Application for Listed Building Consent for Alterations, Extension or Demolition of a Listed Building

Development Listed building consent for the replacement of existing 3 No. PVCu windows with 3 No. new double glazed PVCu windows.

Location Upper Maisonette 3rd & 4th Floor 5 South Terrace Littlehampton

6, SOUTH TERRACE
LITTLEHAMPTON
MAISONETTE
SCALE 1:100 @ A4.

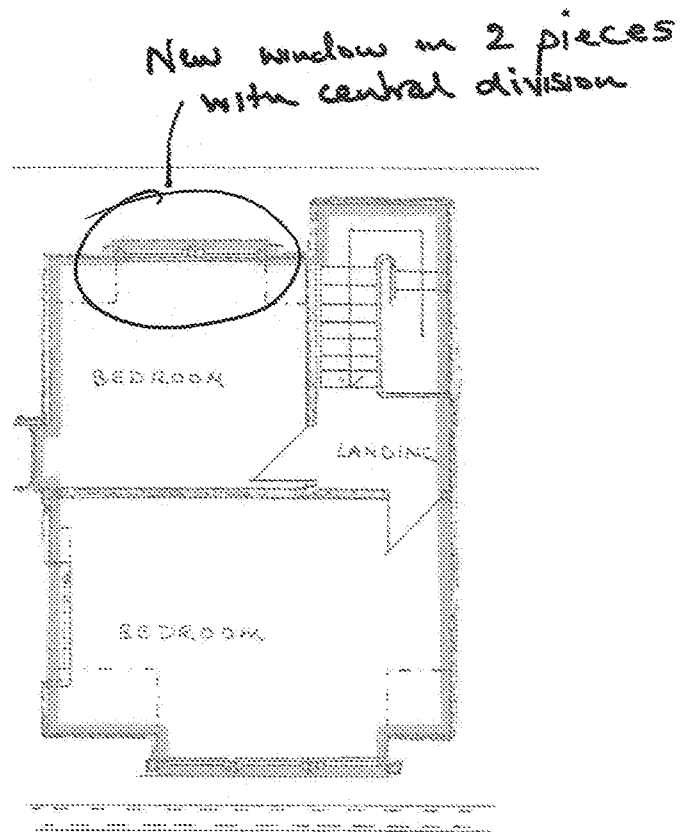
Please clearly highlight the replacement windows on the floor plans.

Please confirm 3 No. windows are being replaced (kitchen, bedroom, bedroom).
